Application for a non-material amendment following a grant of planning permission.

Conversion of the ground floor of a 20th Century garage, attached to a Grade II Listed Building, into living accommodation. Retention of existing external fabric including garage doors and new internal partitioning within the garage and new internal door to link the garage to the main house. Replace existing window in rear elevation with glazed double doors.

Reference number:	<input type="text" value="20/P/01908"/>
-------------------	---

Remove the kitchen from the garage conversion since it is not intended that this area should be used as a separate unit of accommodation.

scale 1:50 (at A3)
 Date Sept '20
 Ref 1630/05A

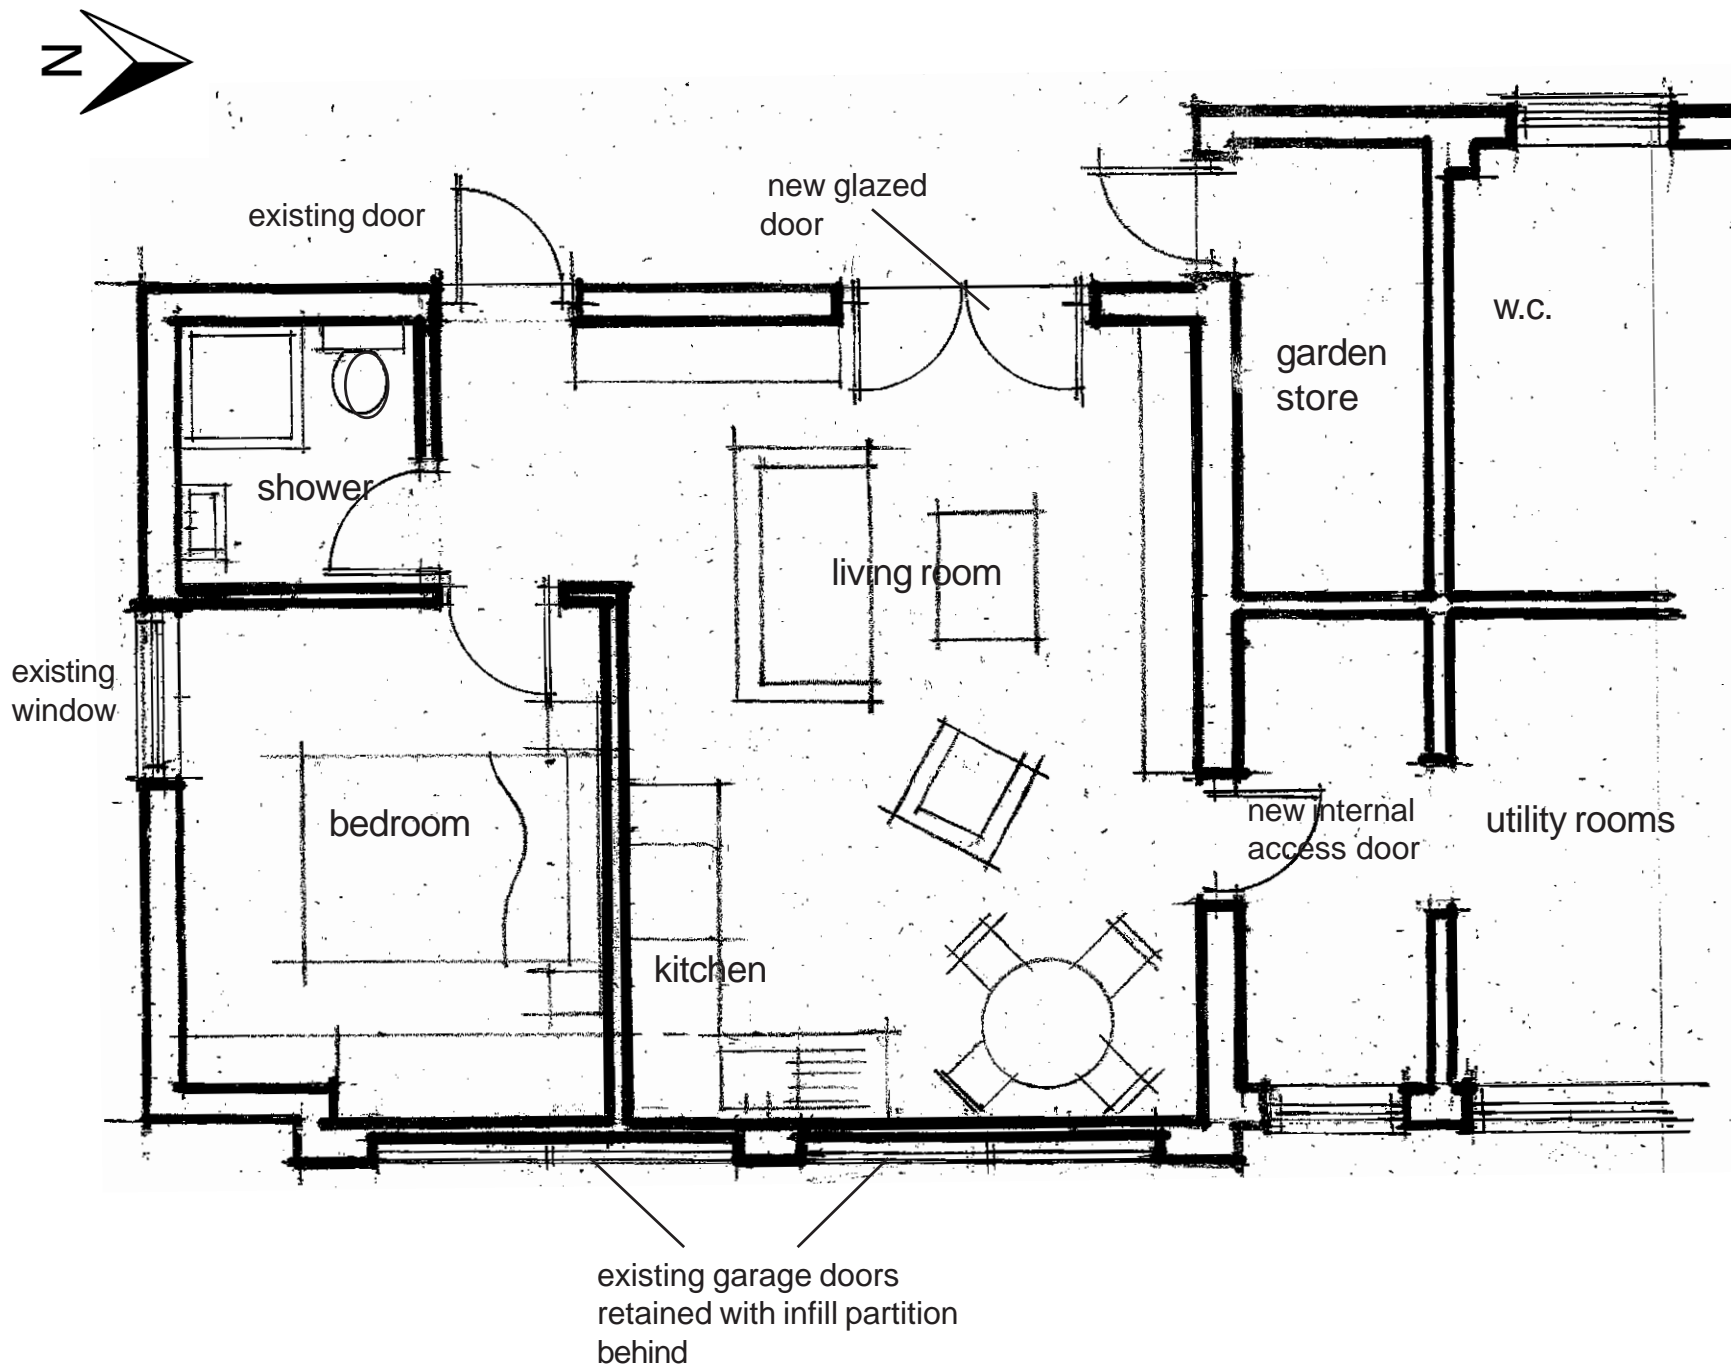
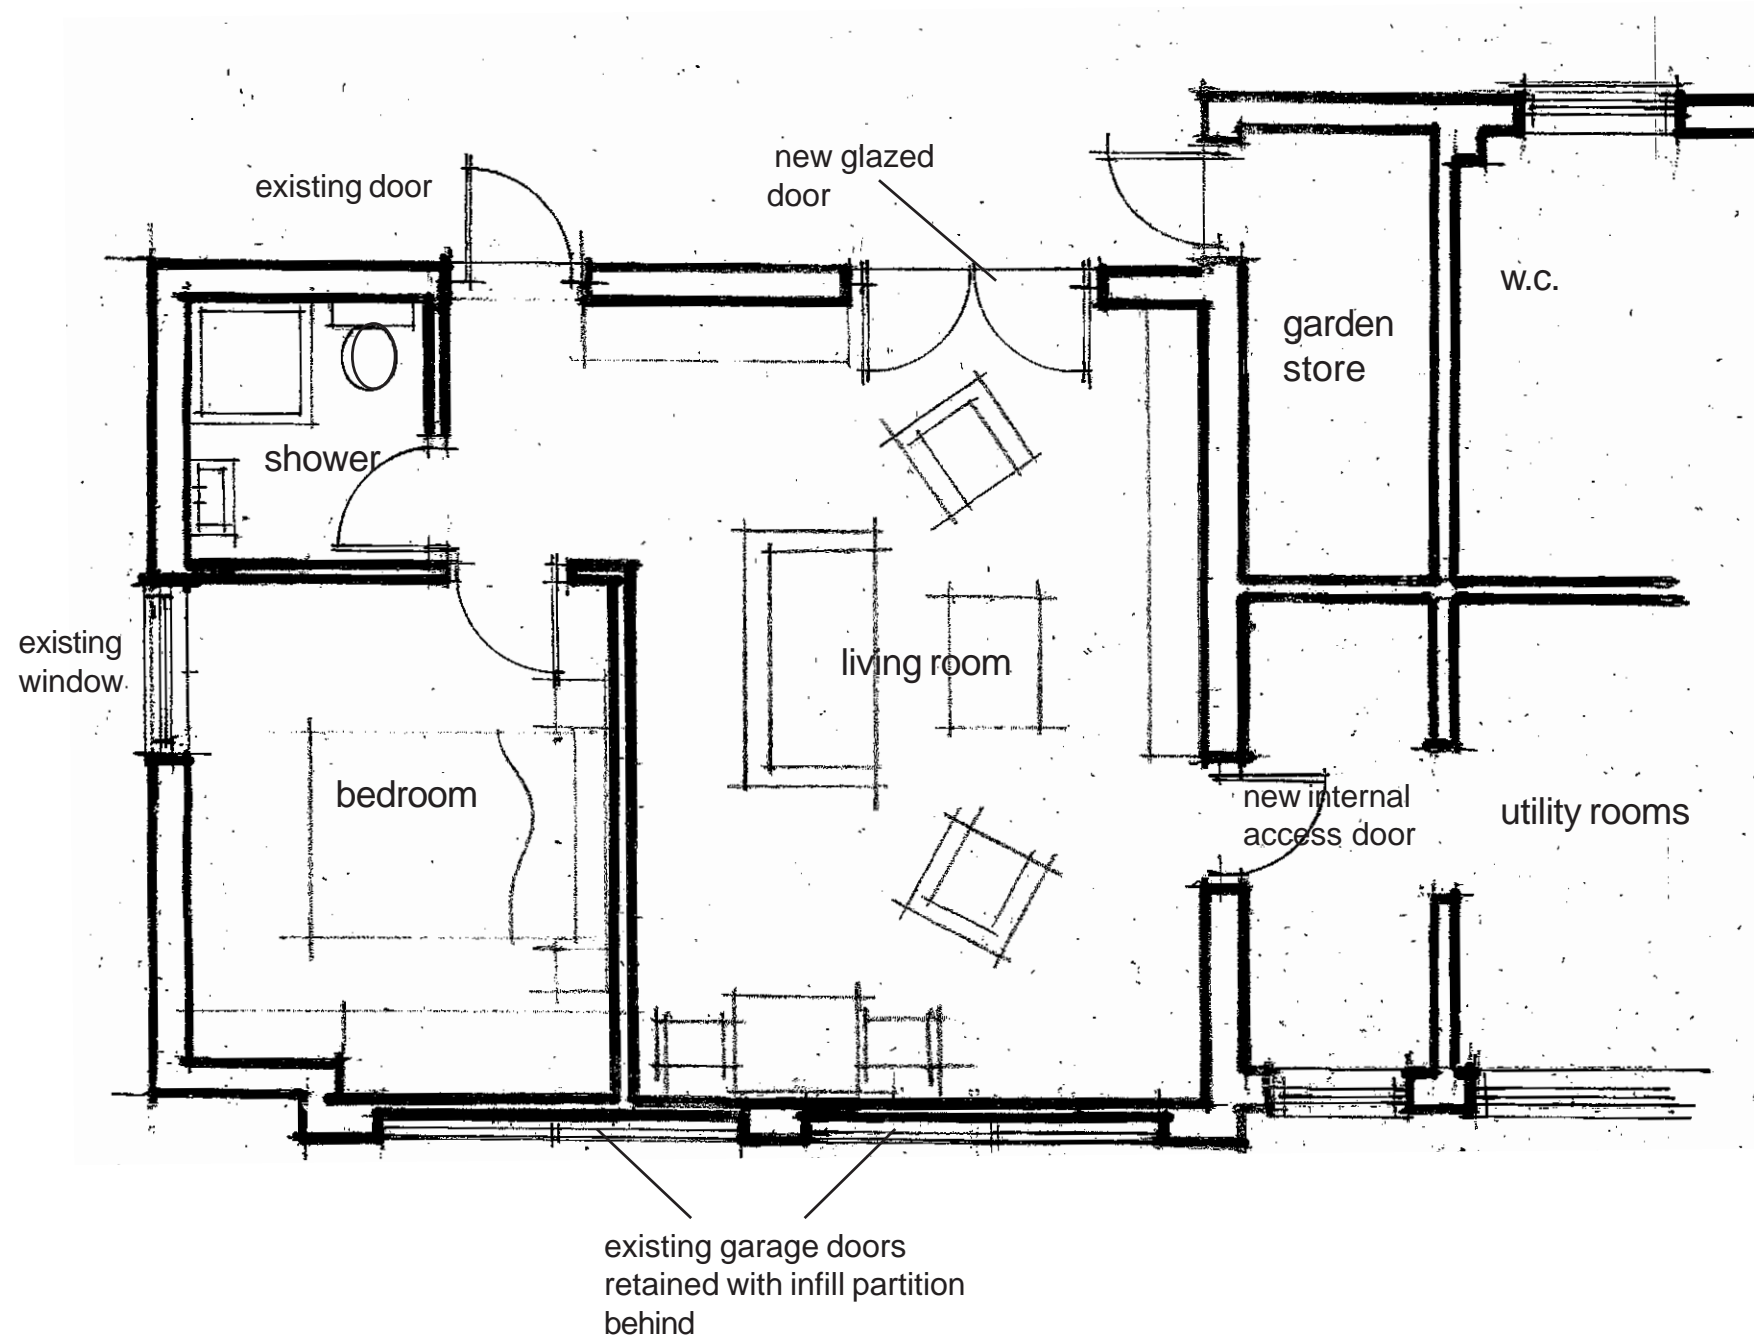
Old plan/drawing numbers

1630/05A Dibbles plan as proposed

1630/05B Dibbles plan as proposed (revised)

It is not intended that this area should be used as a separate unit of accommodation.
